From: Alison Baird
Sent: 09 April 2018 12:05
To: Planning.Responses; Planning
Subject: FW: Further Information Required on Your Ref: 101760 Our Ref: CM/7/18/PL

Please confirm the amended description is satisfactory. — yes Woodpecker Camping Field, Crookthorne Lane, Climping is good thankyou.

block plan 1:500@A2

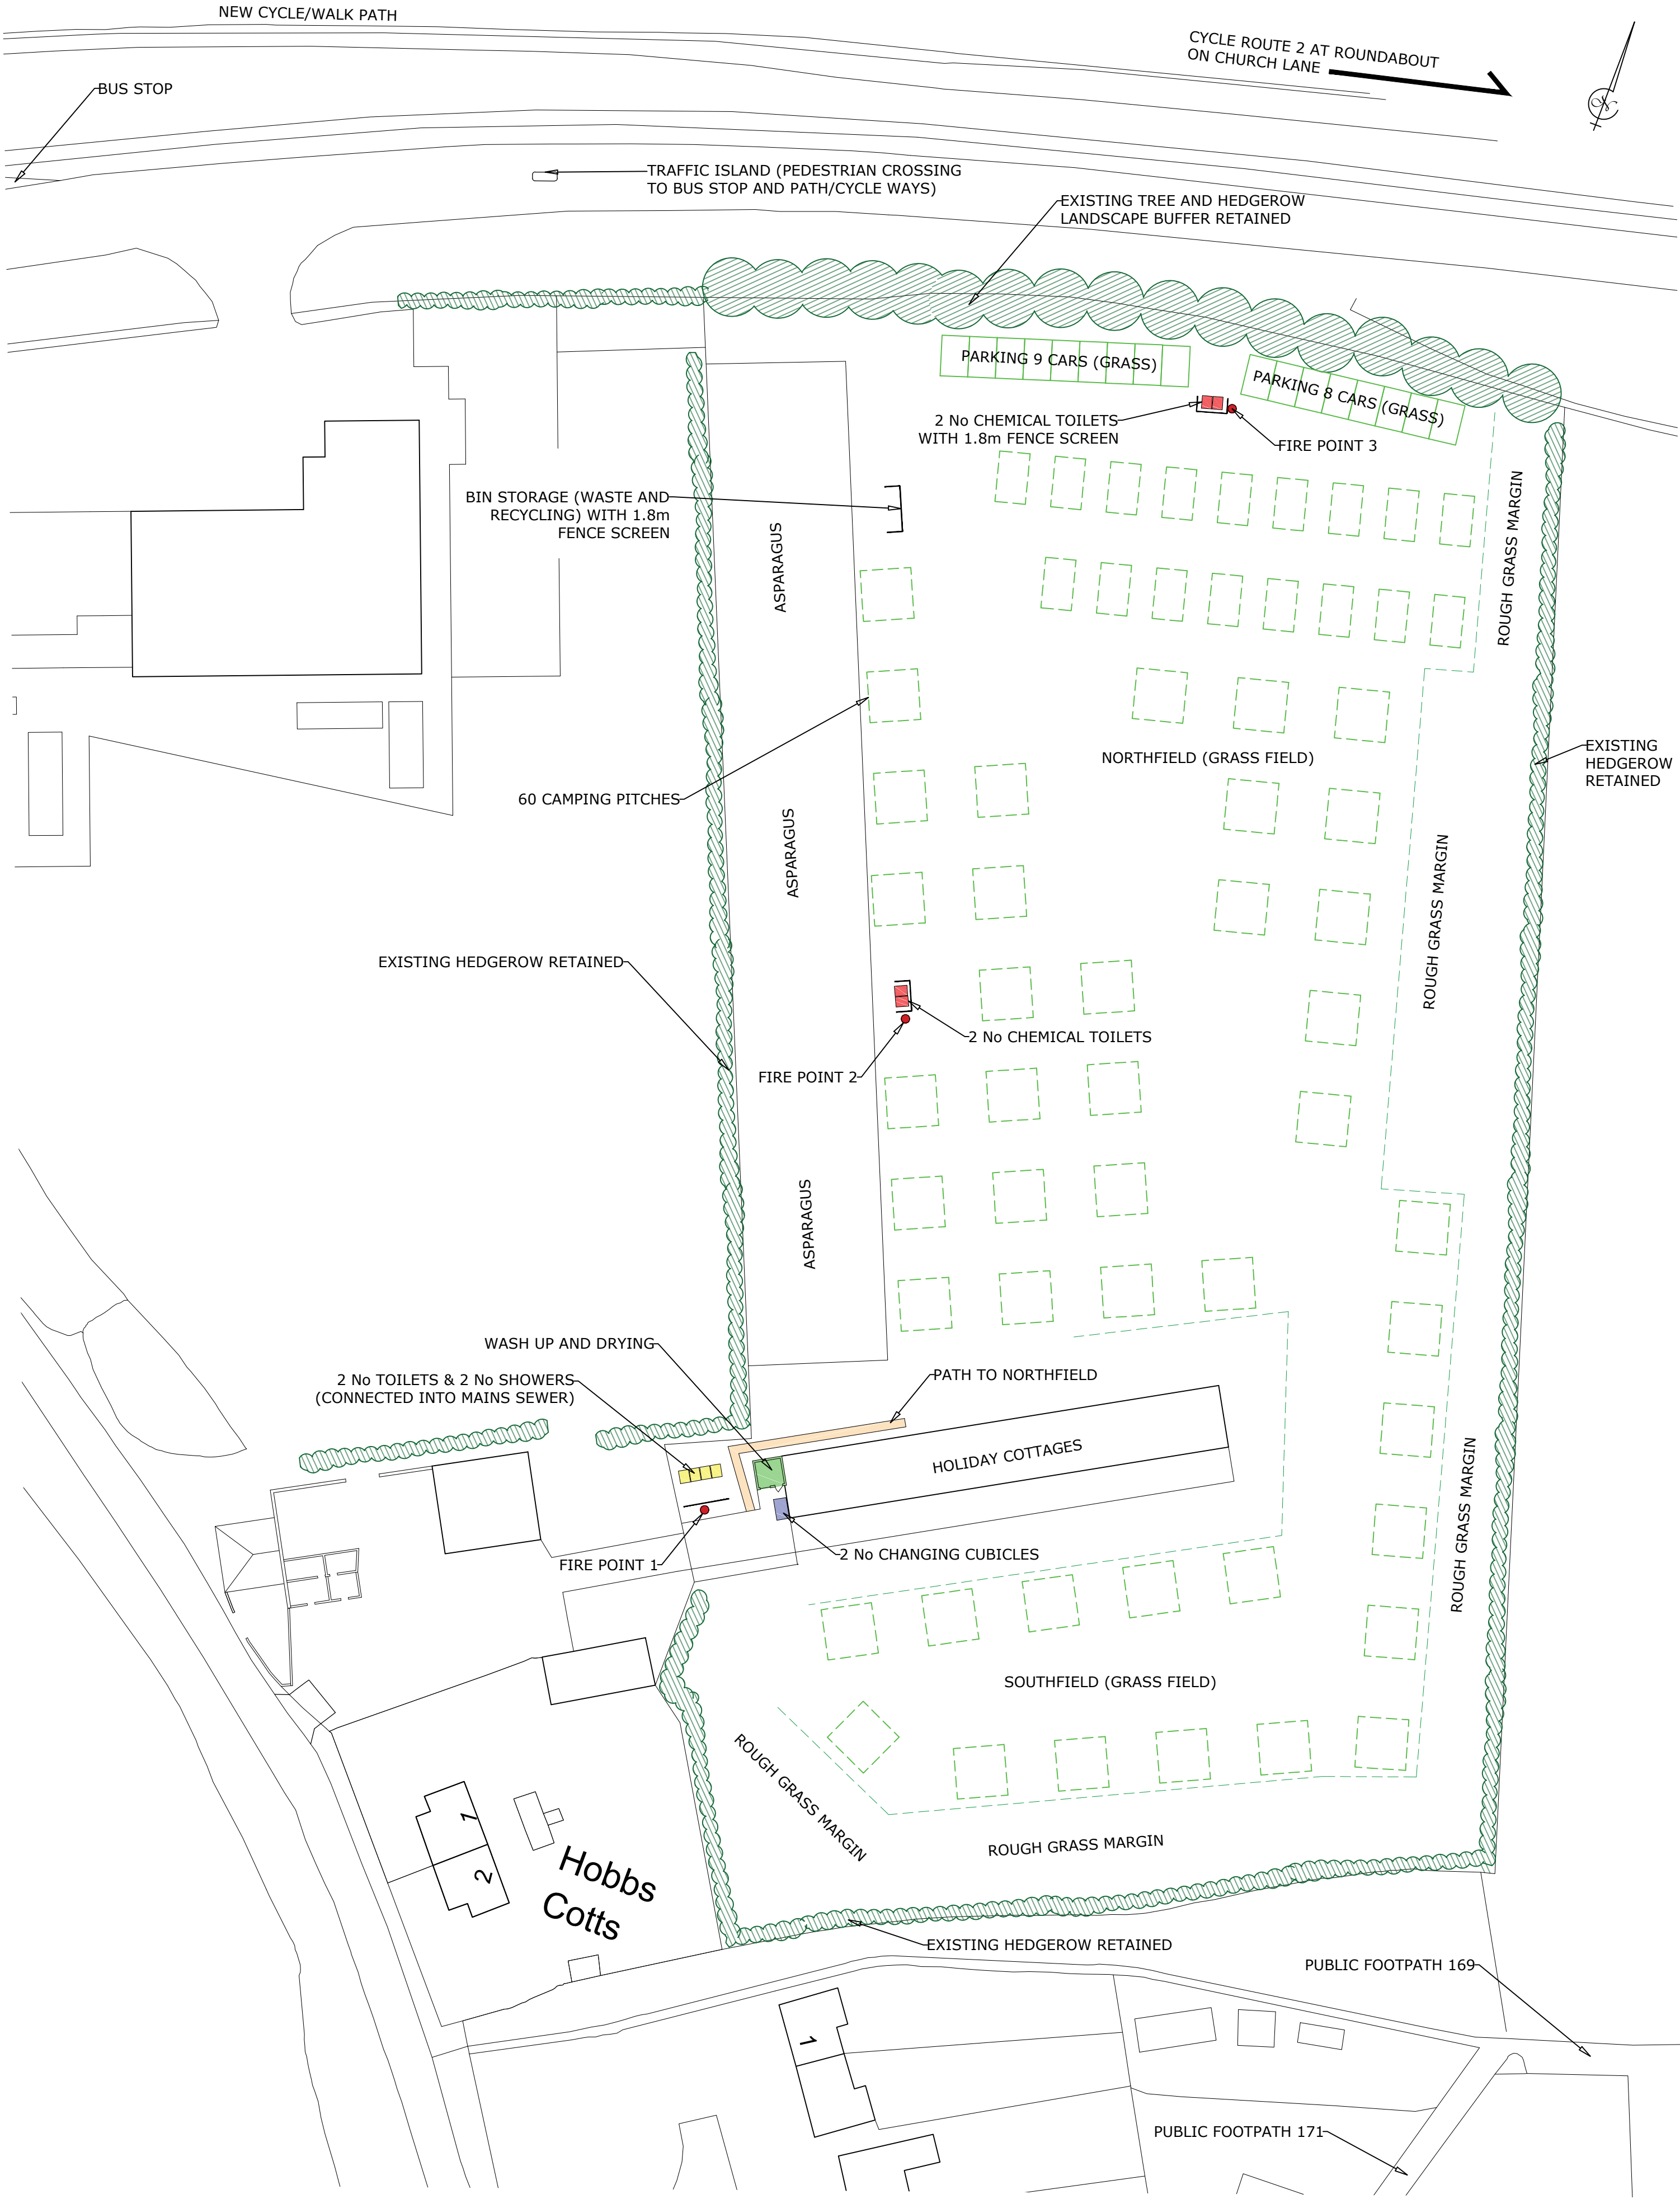
On the application form, 60 parking spaces has been indicated (question 10) whilst the block plan shows 17. Please either amend the application form or the block plan to coincide.
the 60 car park spaces are to allow 1 car per pitch, for the cars parked by the tents. 17 car park spaces alongside the A259 north end close to the smaller pitches and 43 distributed throughout the field parked beside each pitch.
Wasn't really sure how to describe this.

Please confirm if there is any significance between the dotted lines and the solid lines indicating the position of the pitches on the block plan.

I cannot see any solid lines on the block plan, for the pitches as all the lines are dotted to indicate position on the grass, there will not actually be any dotted lines painted on the grass, but there will be markers to identify each pitch number for booking purposes. There are also dotted lines around the edges of the grass field to indicate areas where the grass will be left rough to create buffer zones.

fence screen
1:100@A3

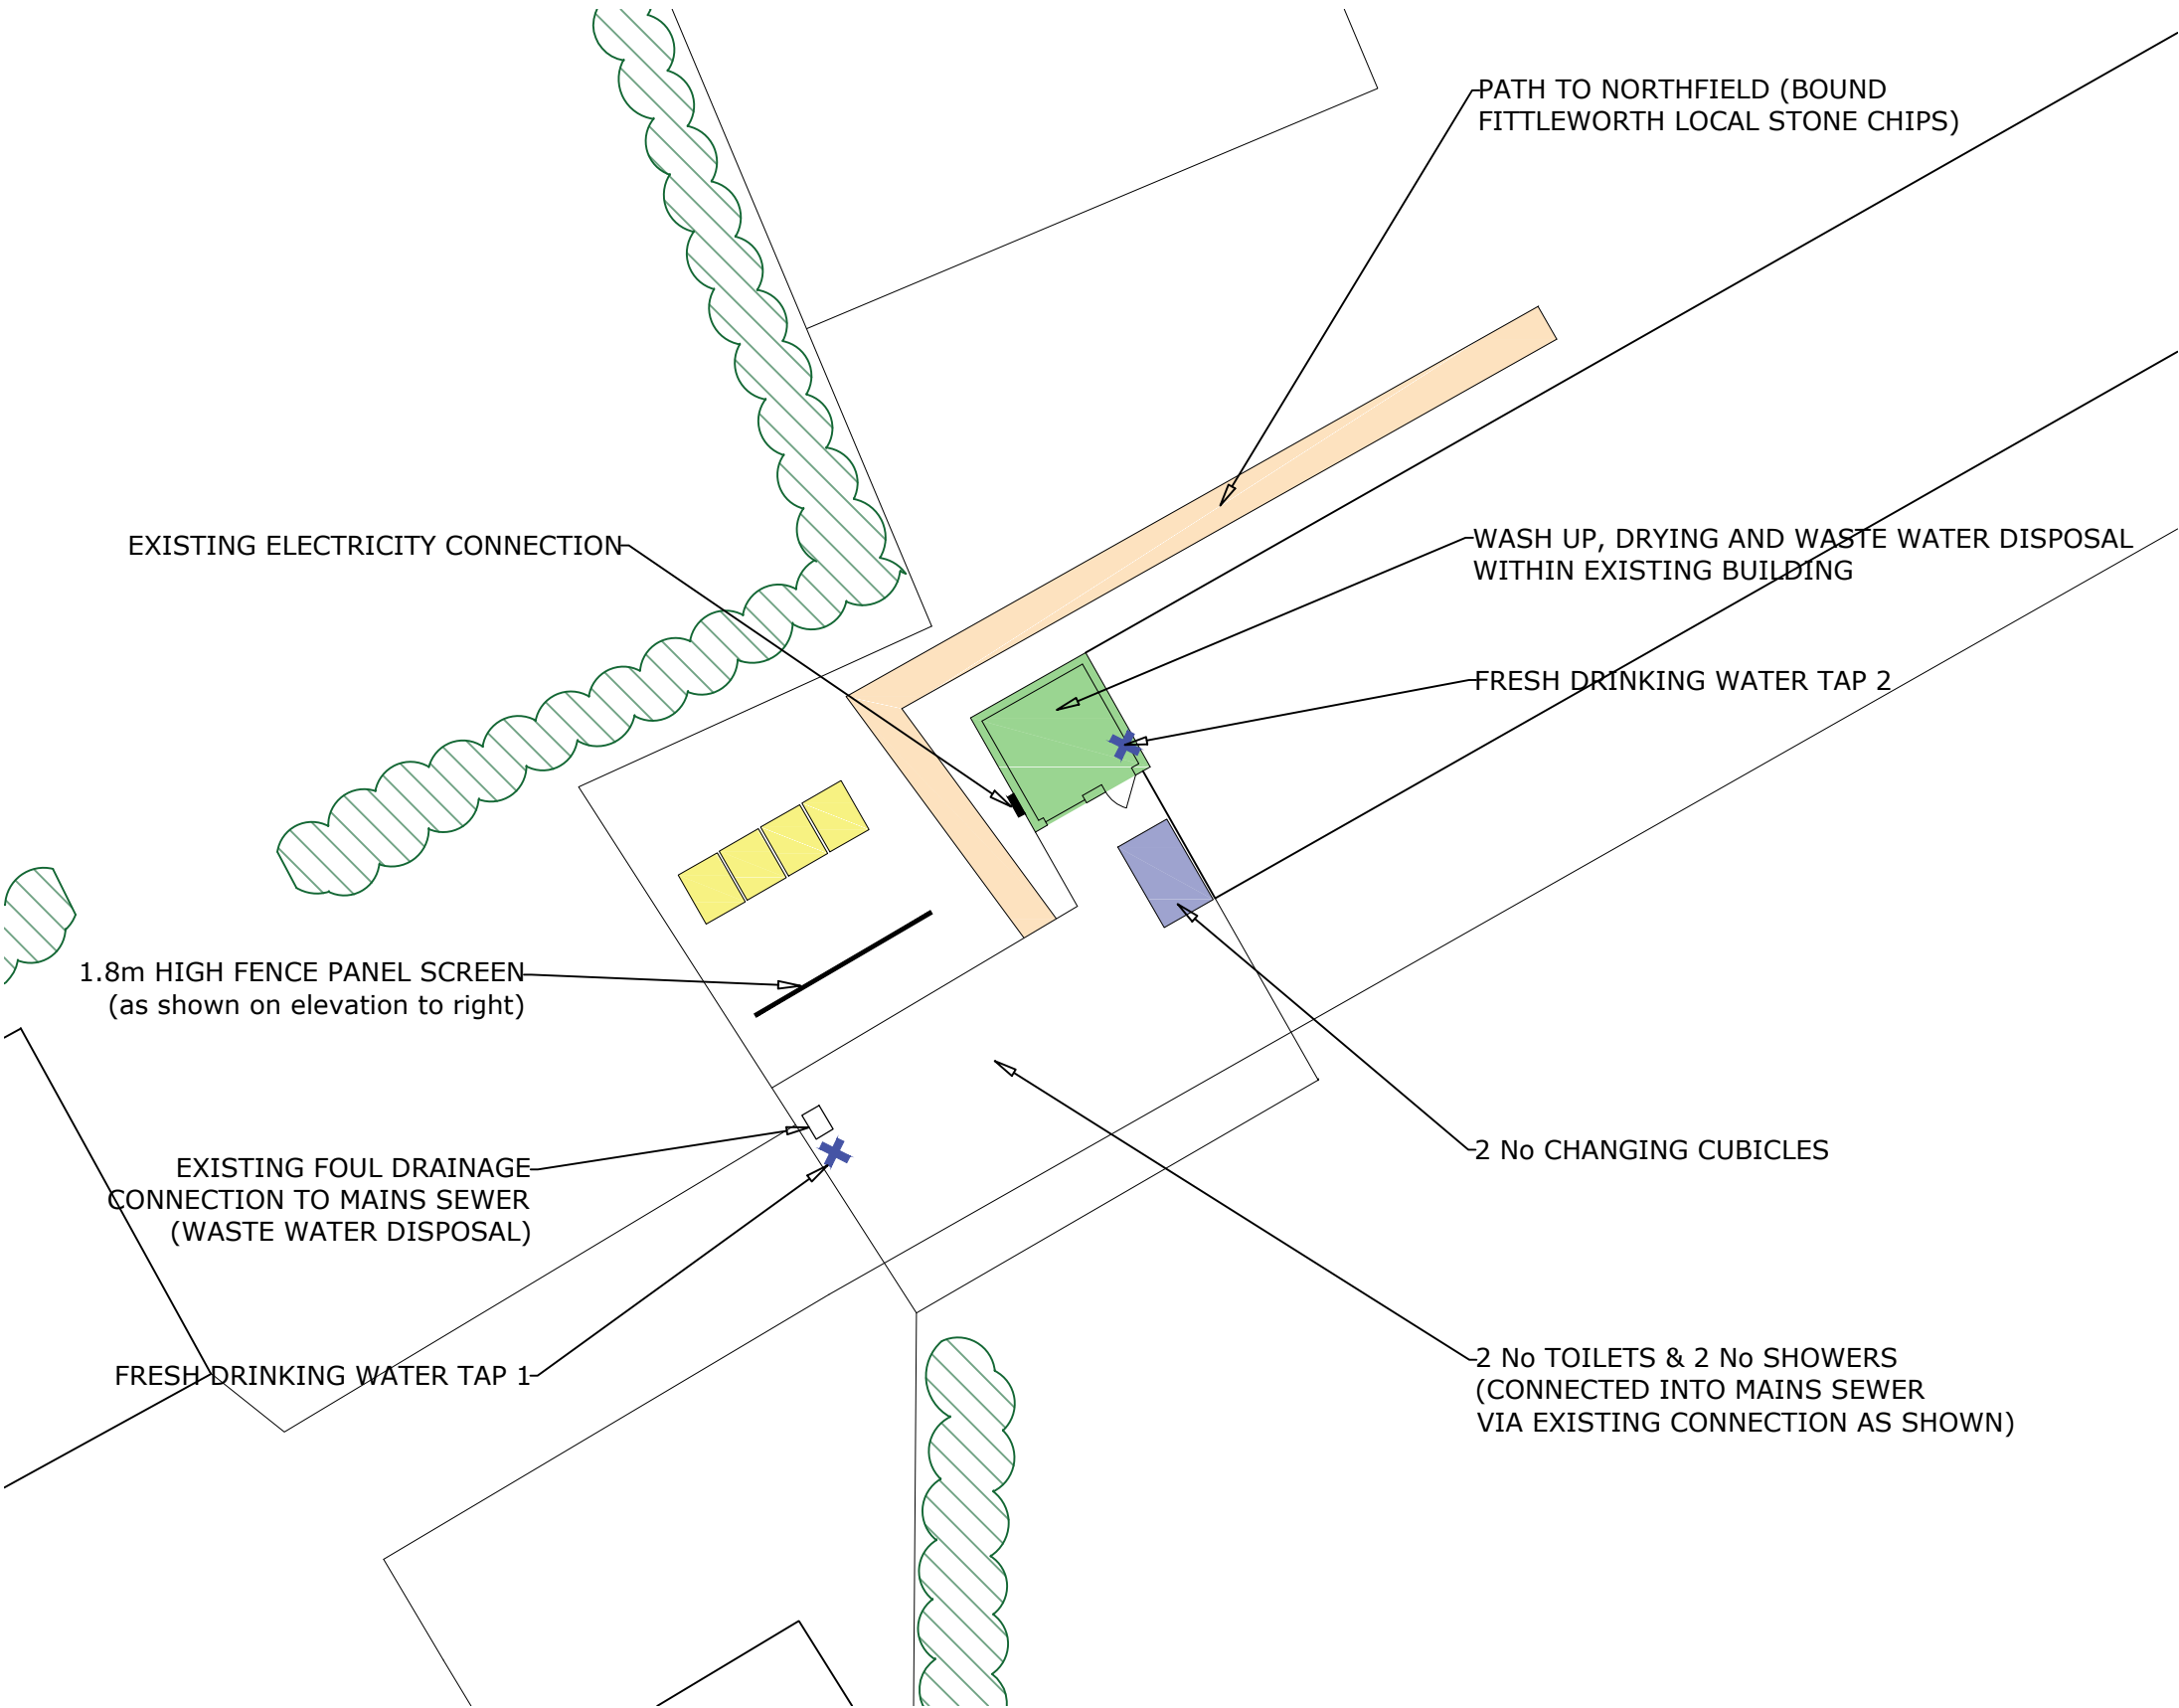
Please provide an elevation of the proposed fence panel screen and provide the measurement in metres.

Please provide an elevation of the fence at the bins store and provide the measurement in metres.

Please find amended plans to reflect the requests above.
